From: T Stevens [REDACTED]
Sent: 15 November 2017 14:49
To: Zac Denton
Cc: Ed; Stuart Clark
Subject: RE: R/1/17/T

I have received Arboricultural comments regarding your application for works at various locations across the Poplars and Parklands Estates, Rustington.

BROOKEN BEE

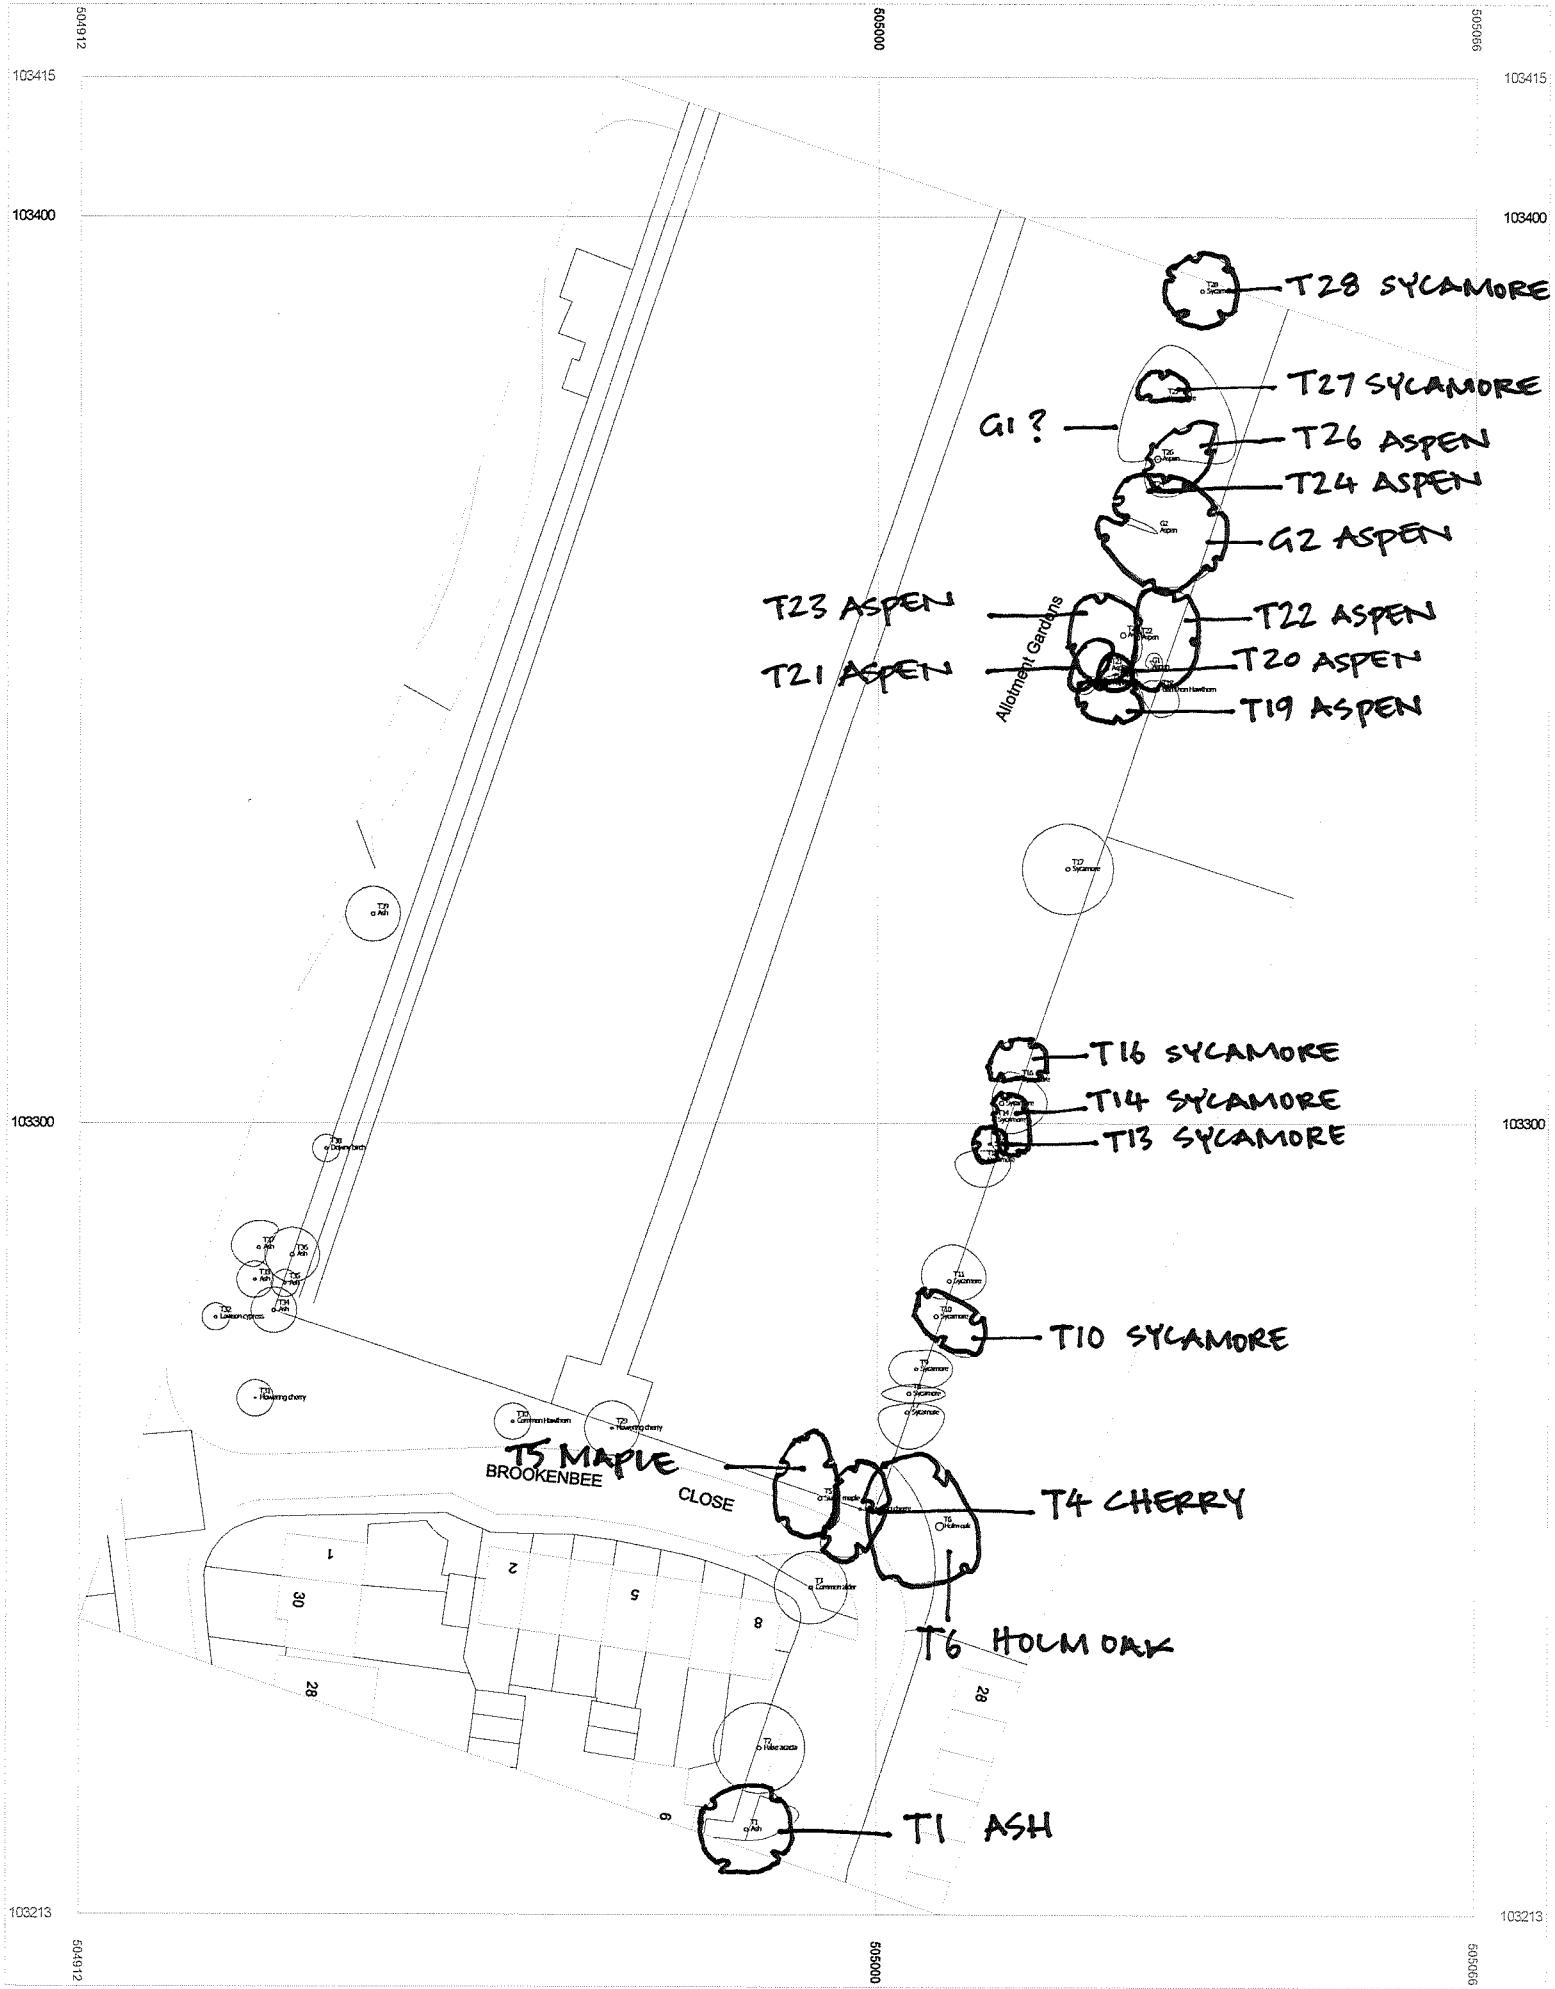
BROOKENBEE CLOSE.

Please confirm that works to T16, T22, T23, T24, T26, T39 and T1 will no longer form part of the application, and will therefore require resubmission.

PARKLAND HUTCHINSON SUMMERLY FOXES, - NORTH

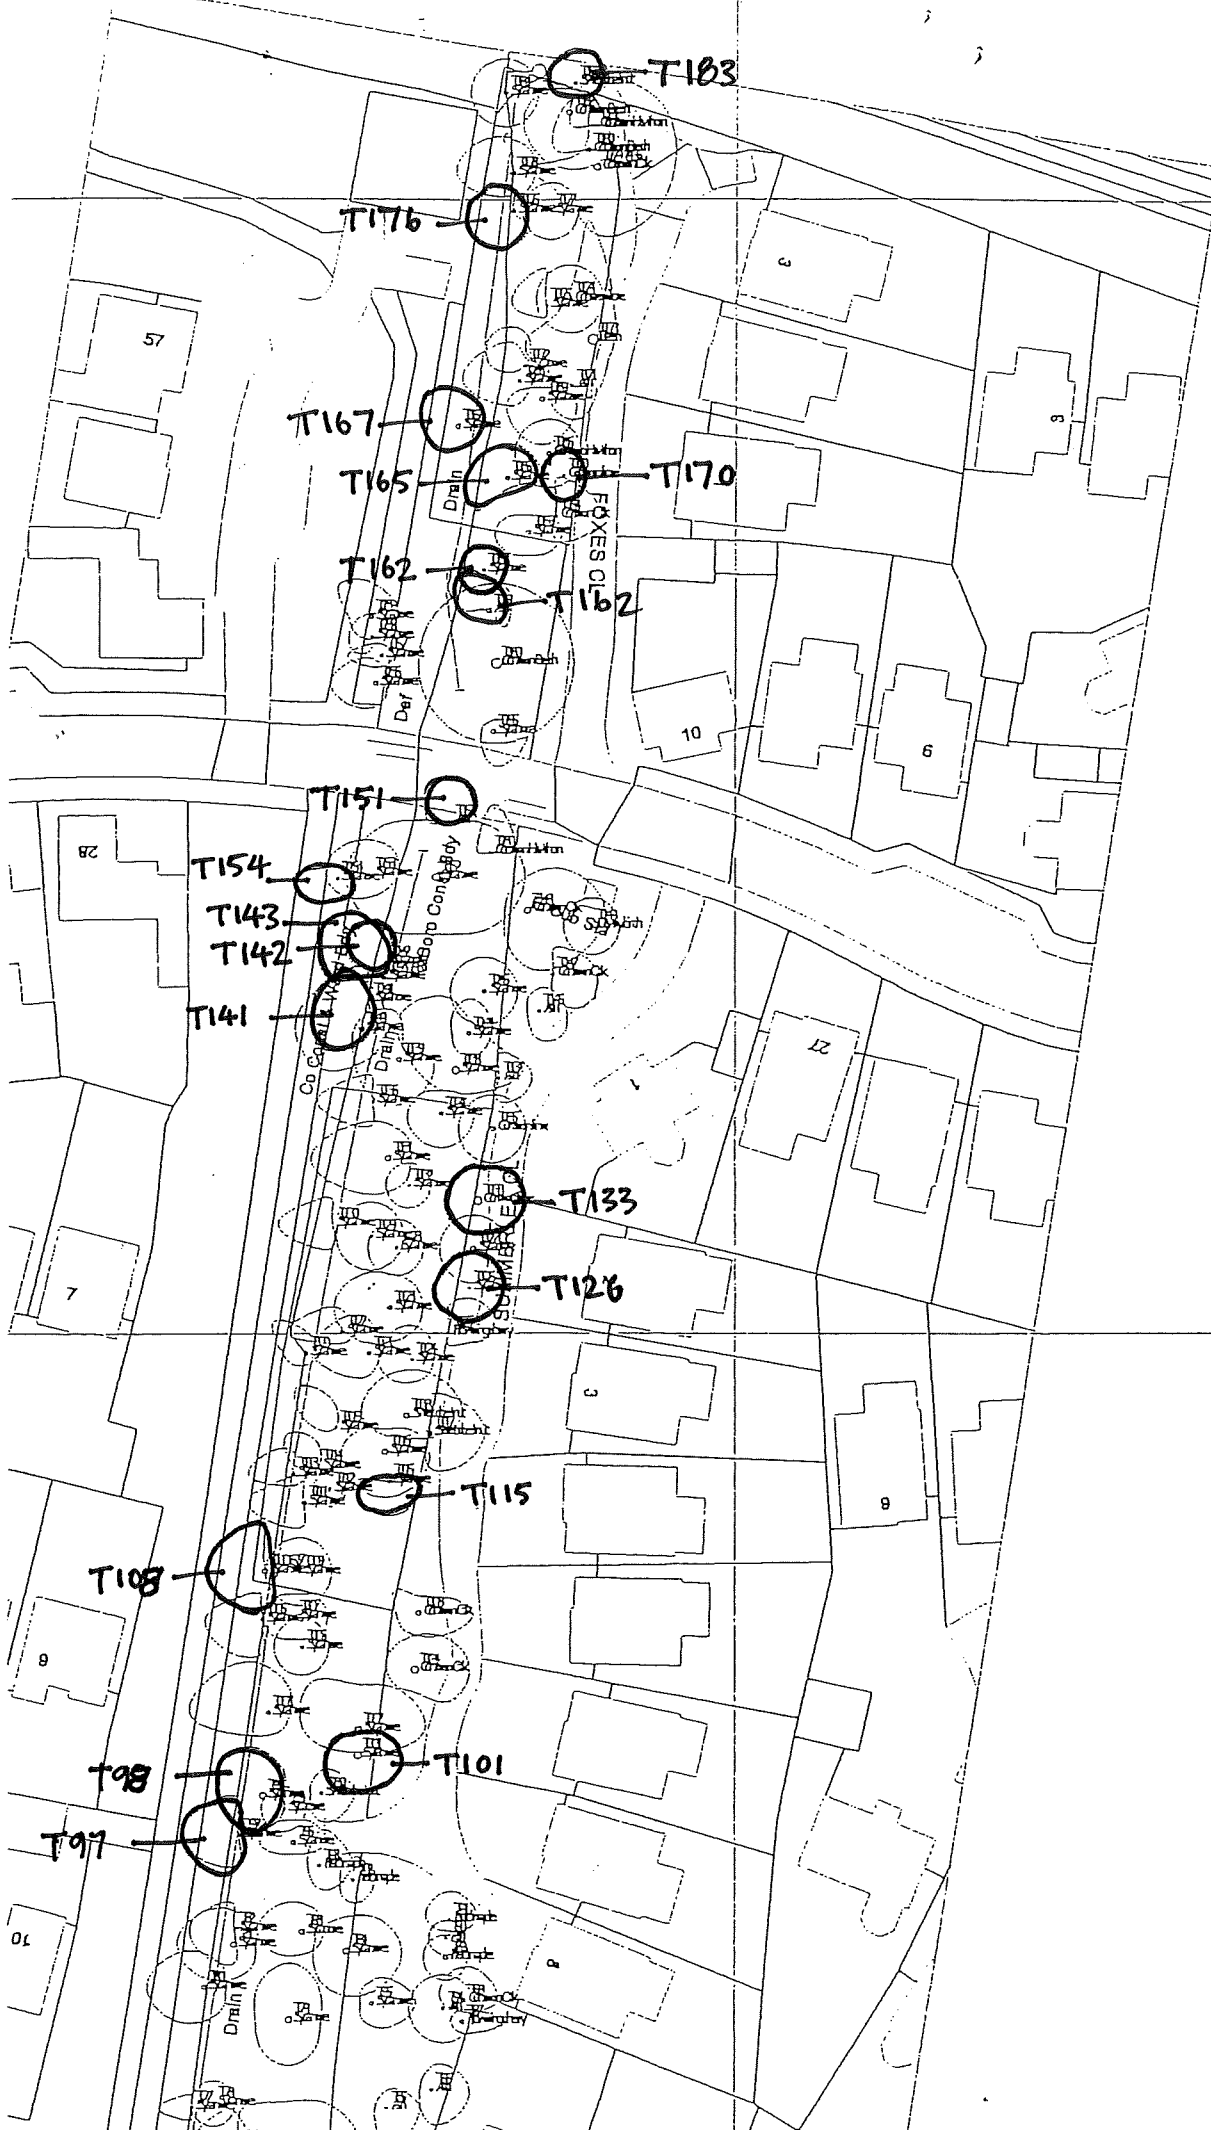
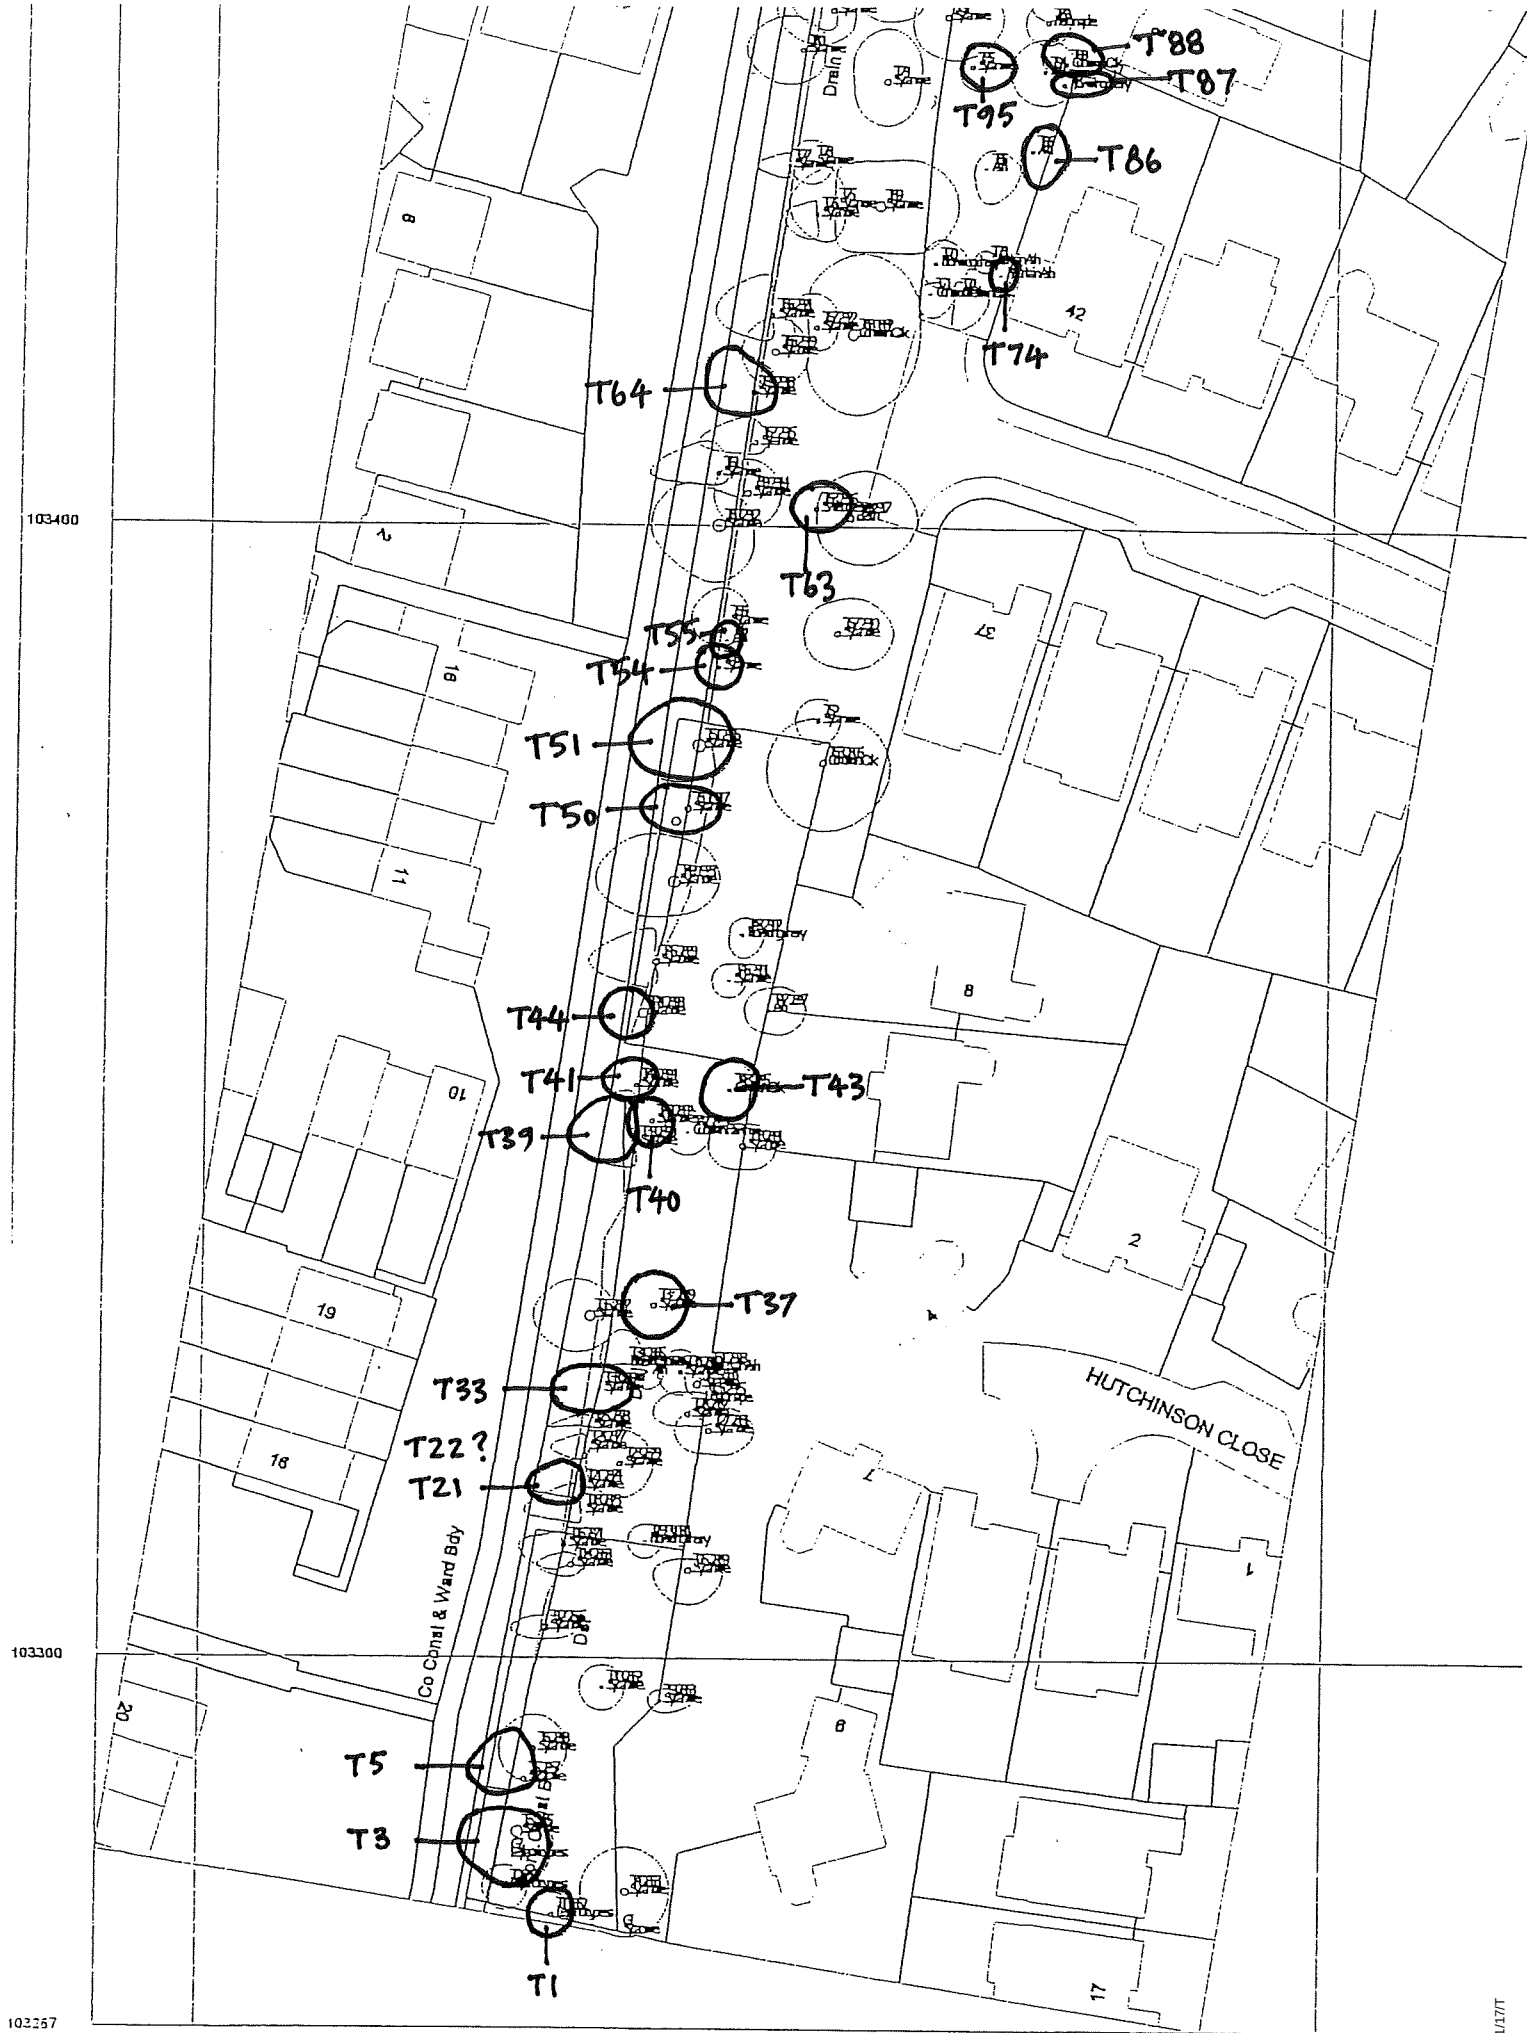
HUTCHINSON CLOSE/SUMMERLEY CLOSE/ FOXES CLOSE

Please confirm that works to T5, T44, T141 and T160 will no longer form part of the application, and will therefore require resubmission.

PARKLANDS / COWDRAY DRIVE

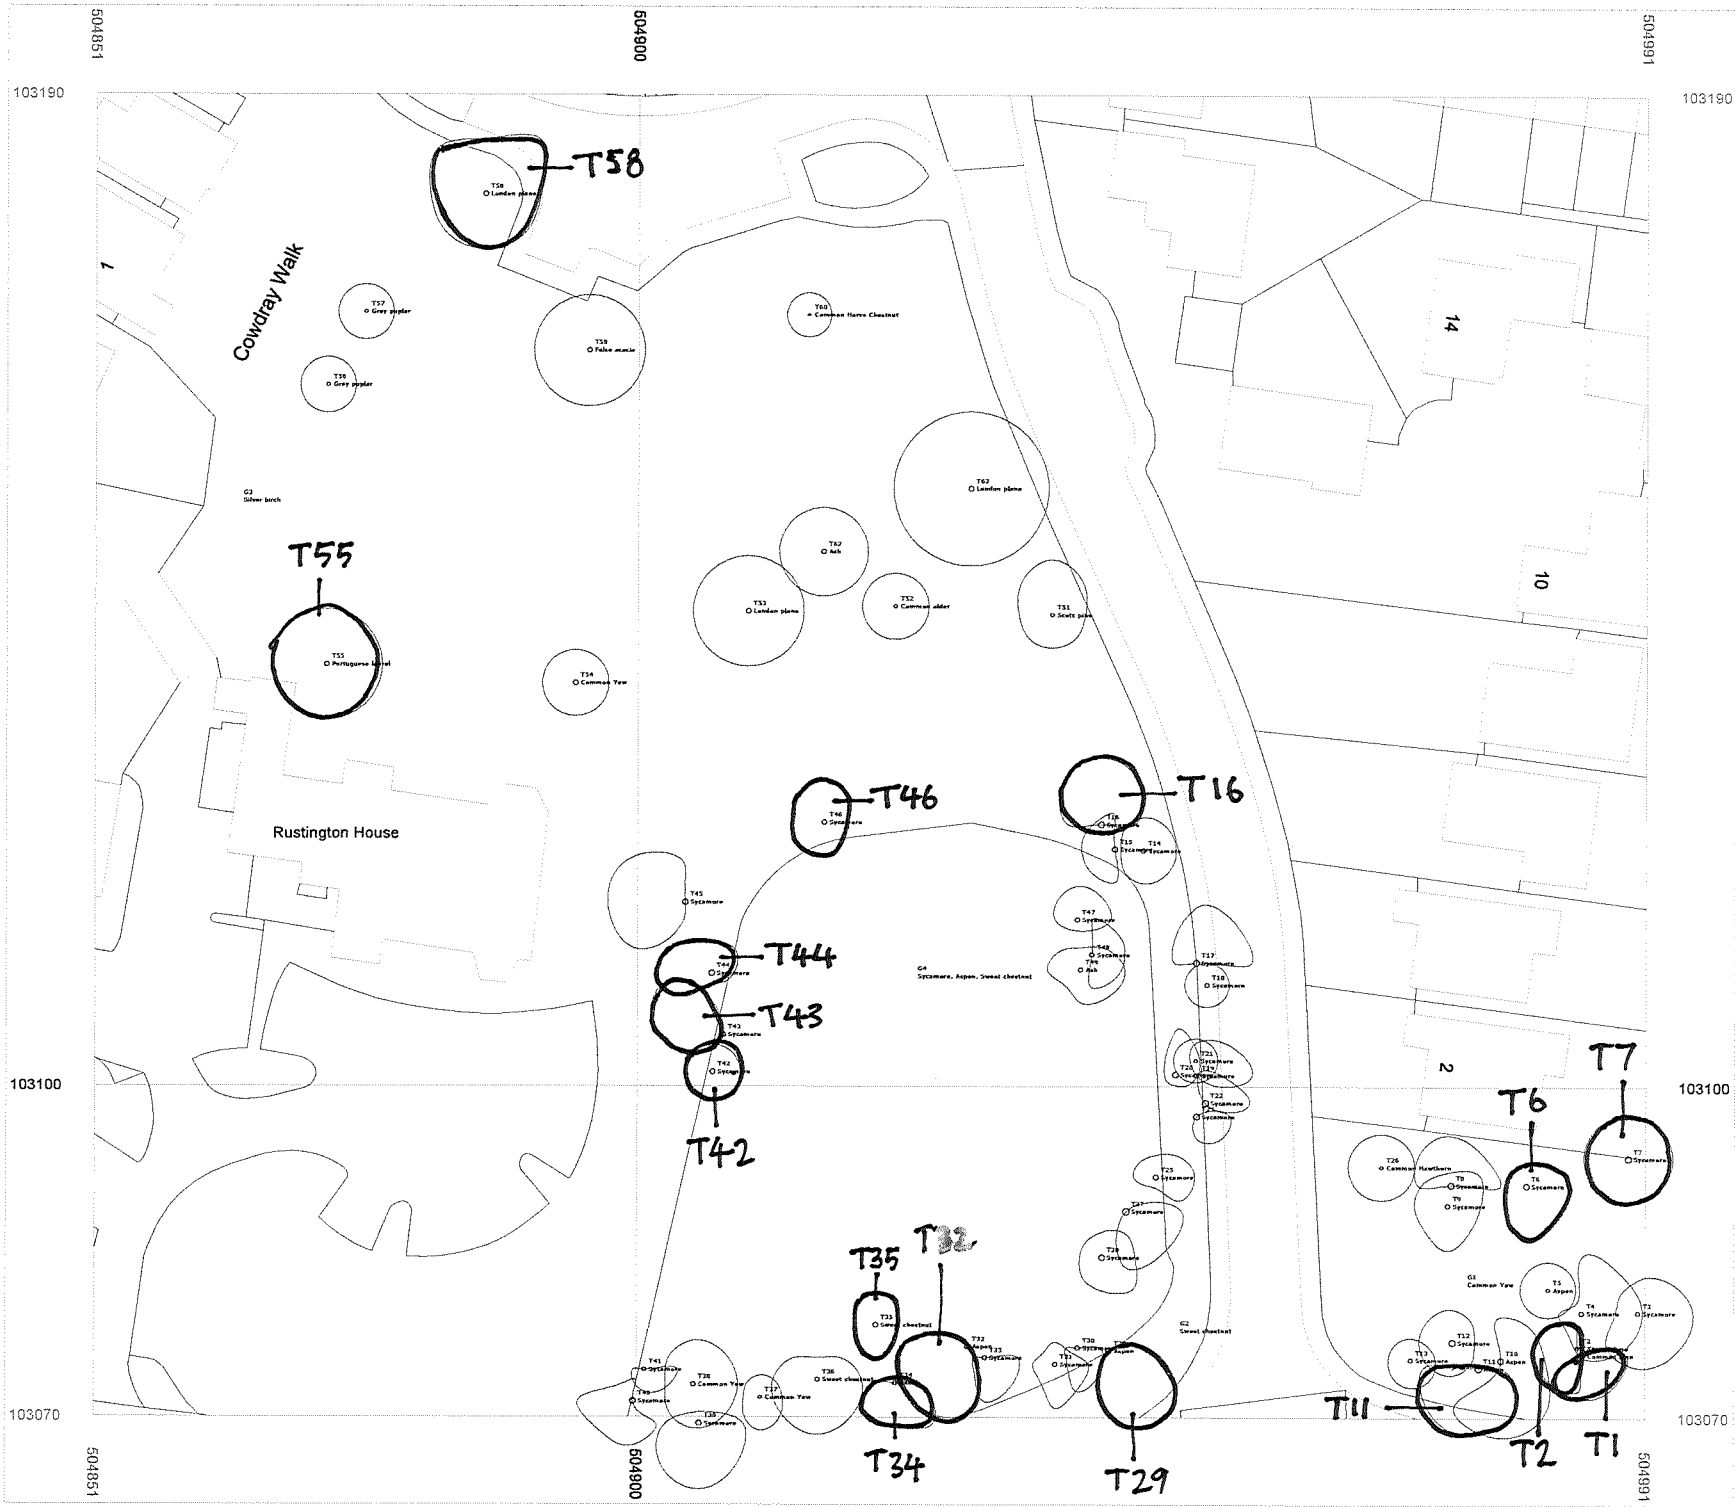
PARKLANDS/COWDRAY DRIVE

Please confirm that works to T6, T7, T11, T16, T34, T55 and T58 will no longer form part of the application, and will therefore require resubmission.
